Your Ref: OWPC25503
Our Ref: FG/148/19/HH 22-11-2019
Please ask for:
Zac Denton

Creation of a second vehicular entrance to the property with a new bridge over the ditch an extended driveway and changes to hard and soft landscaping
14C Sark Gardens Ferring

Thank you for your internet representation made on 24th January 2020 which has been recorded as '**an objection**' with the comments as follows:

14C2 v2

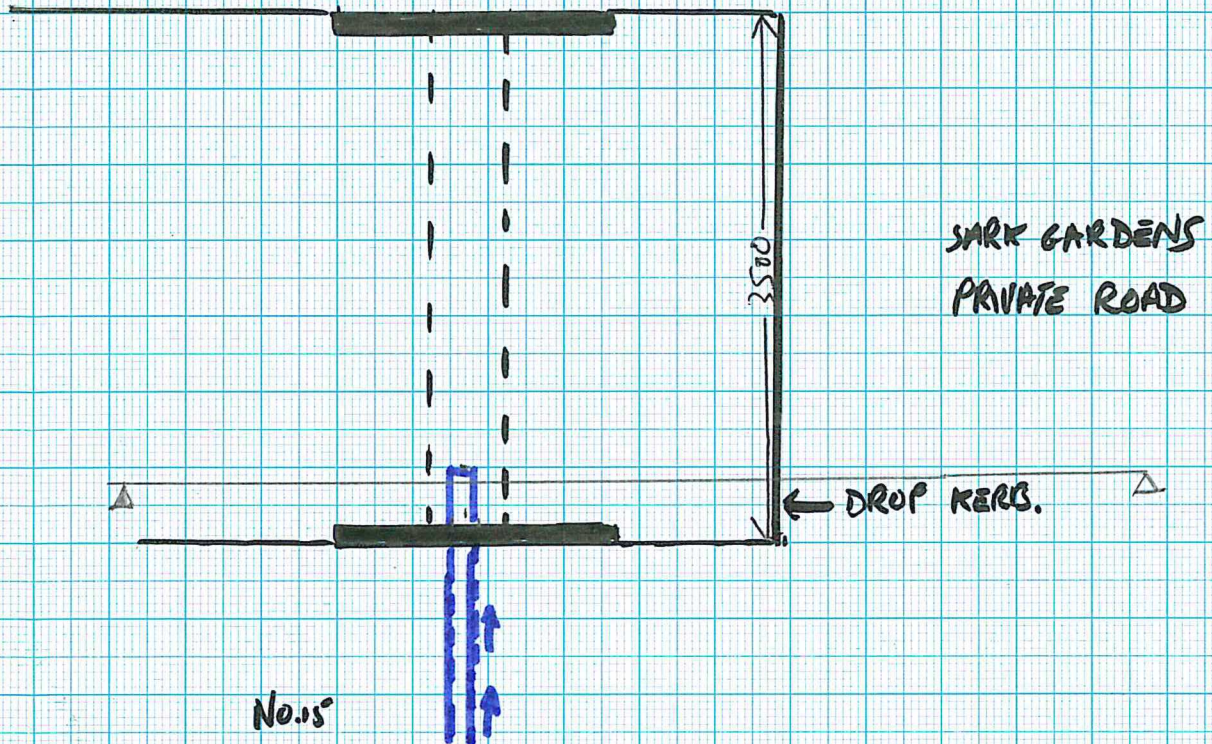
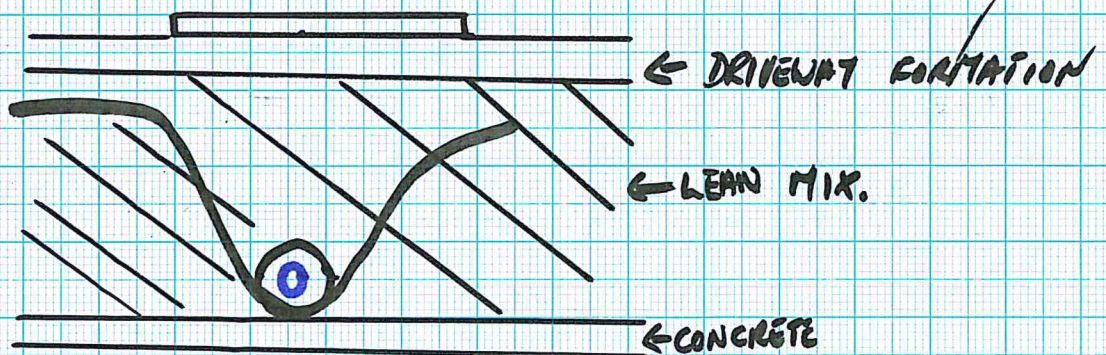
It was also constructed incorrectly the culvert being too high for the ditch level and as a result holds water back from free flowing into the underground system leading into Jersey Road.

The ditch requires dredging to a more effective level as it is the only catchment for the close in heavy rain and acts as a soak away for all the properties in the absence of a surface water system in the village.

The plans and details as submitted do not appear to be very professional and the construction unclear plus the flow of surface incorrect as the flow is West into the centre of the village via Jersey Road.
